From: [Alex Hill](#)
To: [Rachel Mitchell \(Health Infrastructure\)](#)
Cc: [David Gibson](#)
Subject: SSD 6980 MOD 2 - Brookvale Community Health Centre - Outstanding Issues
Date: Friday, 8 March 2019 4:26:00 PM
Attachments: [Council response to request for comments.DOCX](#)
[image009.png](#)
[image010.jpg](#)
[image011.jpg](#)
[image012.jpg](#)

I have completed a preliminary assessment of the modification application for Brookvale Community Health Centre.

SSD 6980 Site Compound

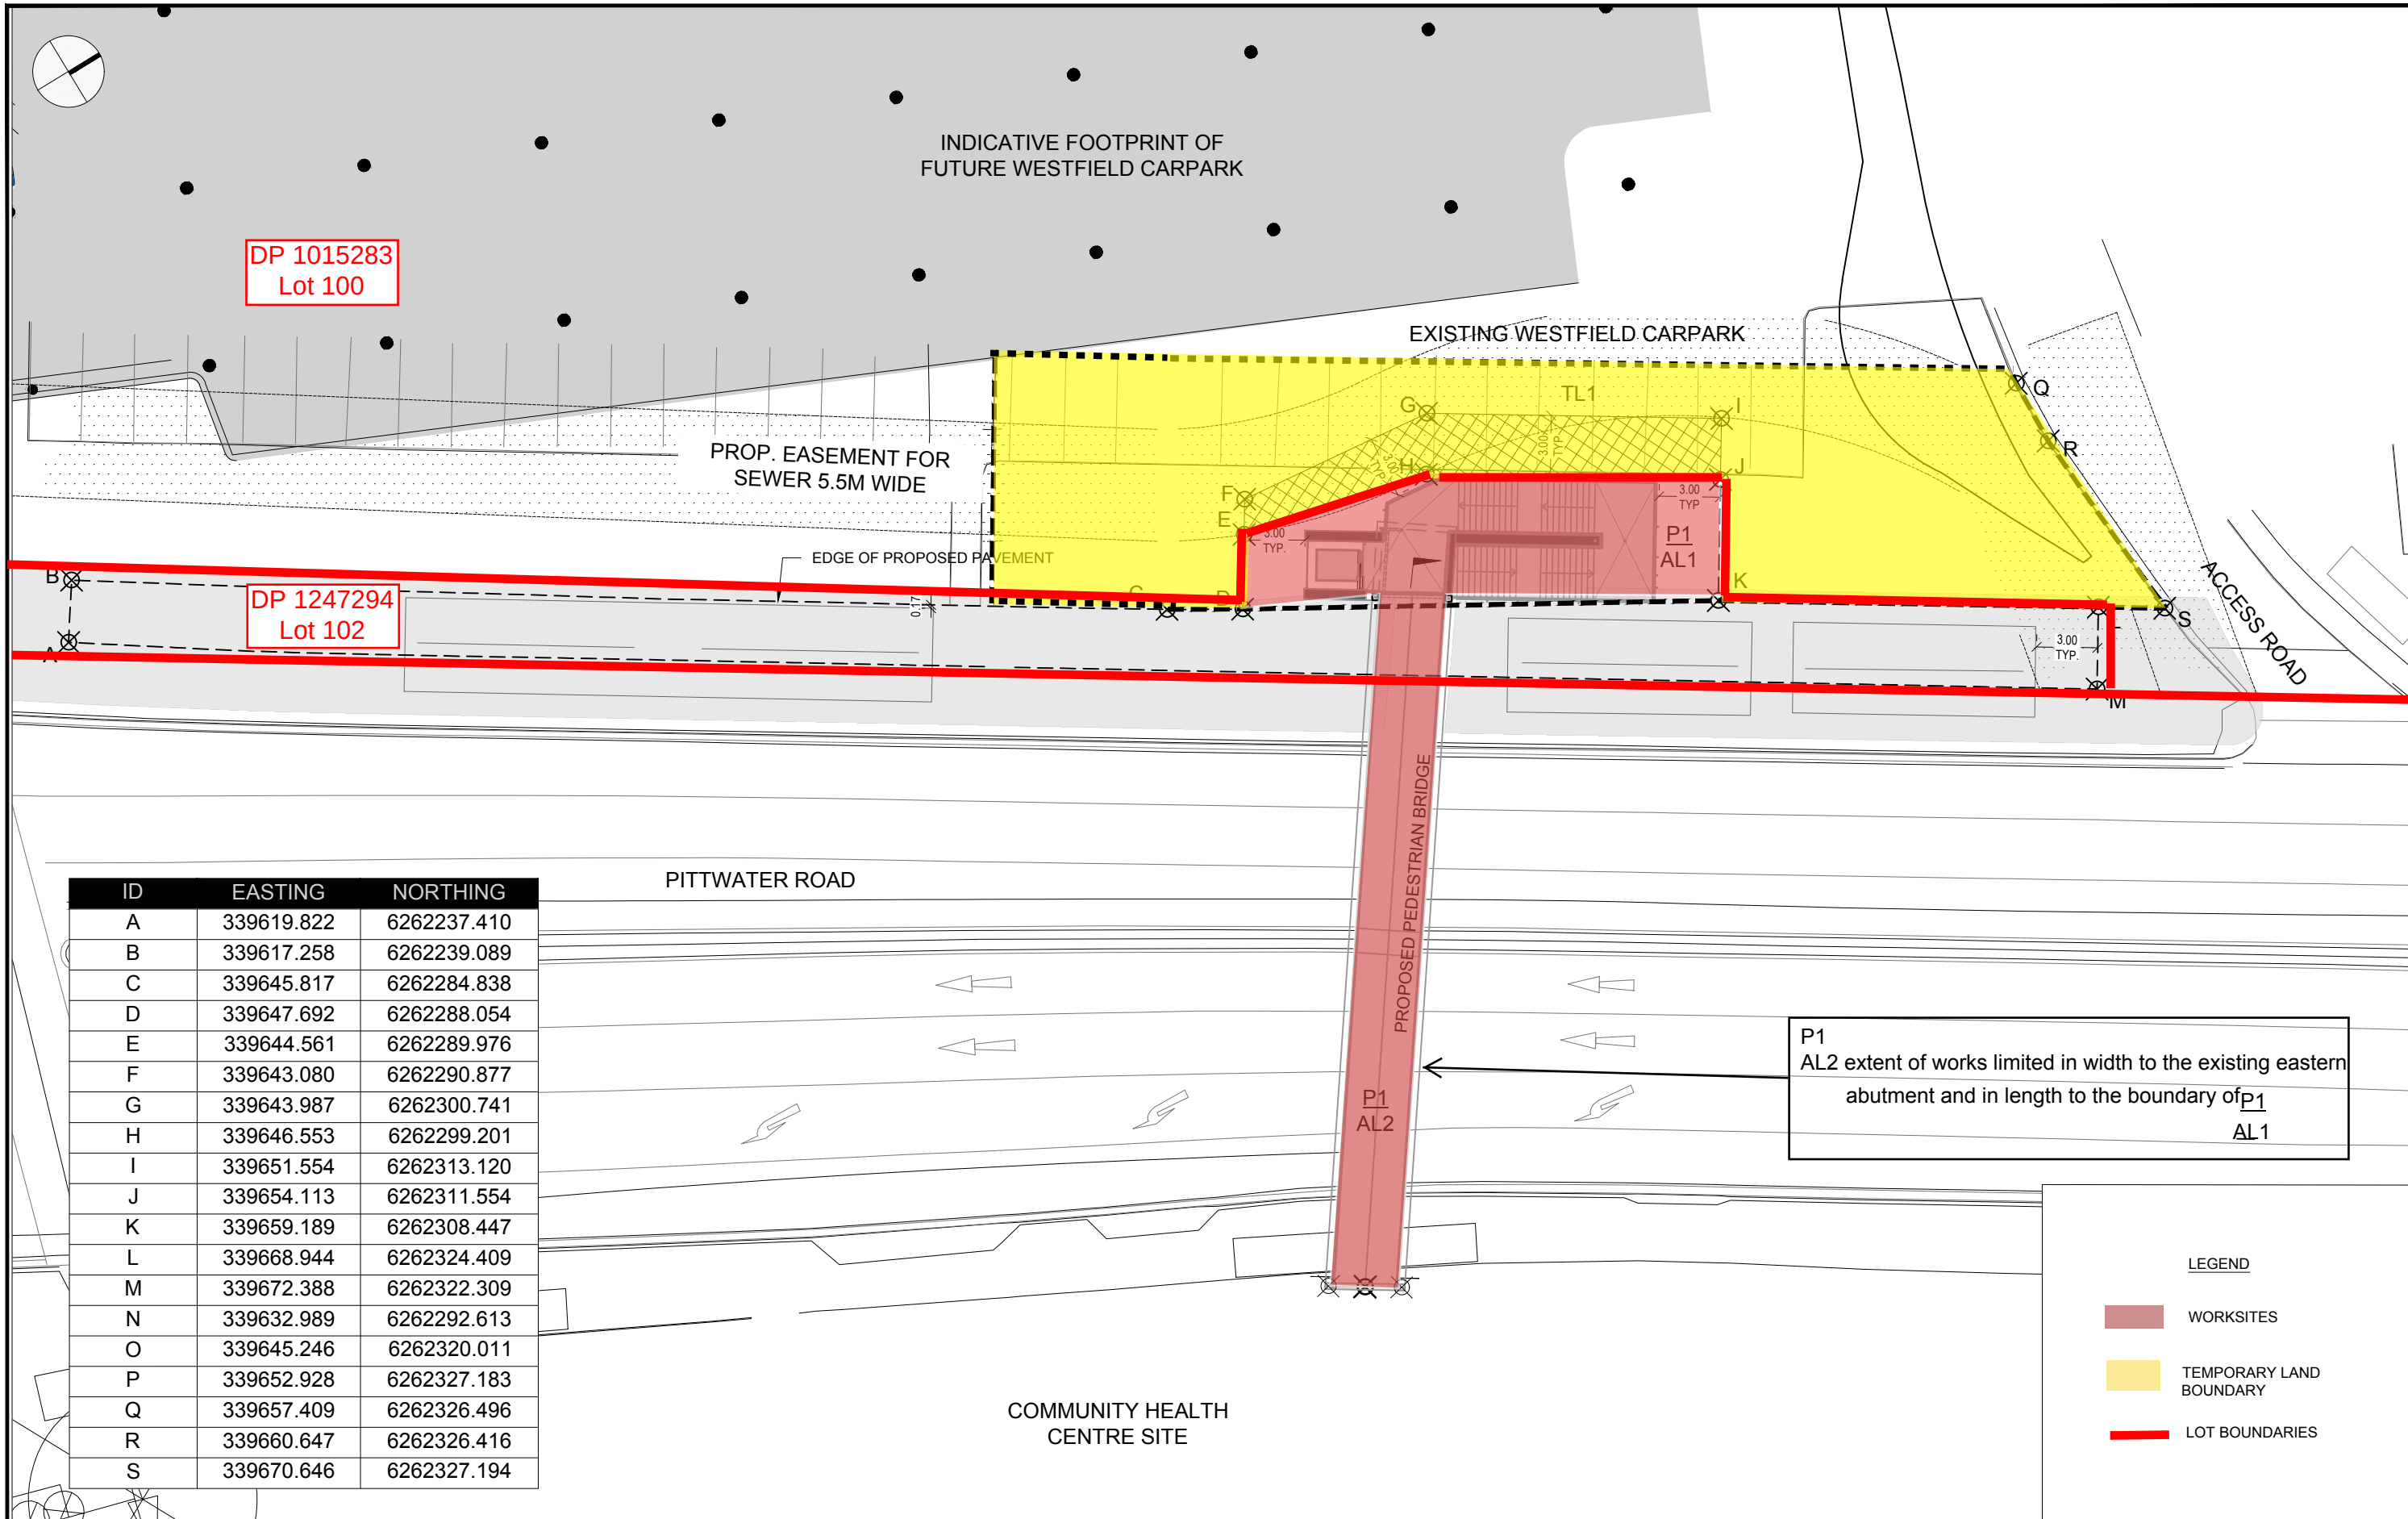
- A revised Site Plan in high resolution
- Clarification of the site plan, including the relevant lots, and owners consent to the works

- No detail of the proposed earthworks is provided by way of plans. As such, the extent of excavation is unclear.
- No Preliminary Site Investigation was submitted with the application, despite the Environmental Assessment indicating that the site may be contaminated. Once the site area is clarified as requested above, please submit a PSI which addresses the subject site.
- Once the proposed earthworks are clarified, please address compliance with Clause 6.1 Acid Sulfate Soils of WLEP 2011 in greater detail. The Environmental Assessment asserts that no excavation below the natural ground level is proposed, but also states that excavation of up to 1m is proposed, and additional earthworks to install utilities may occur. If necessary, please prepare an Acid Sulfate Soils Management Plan.
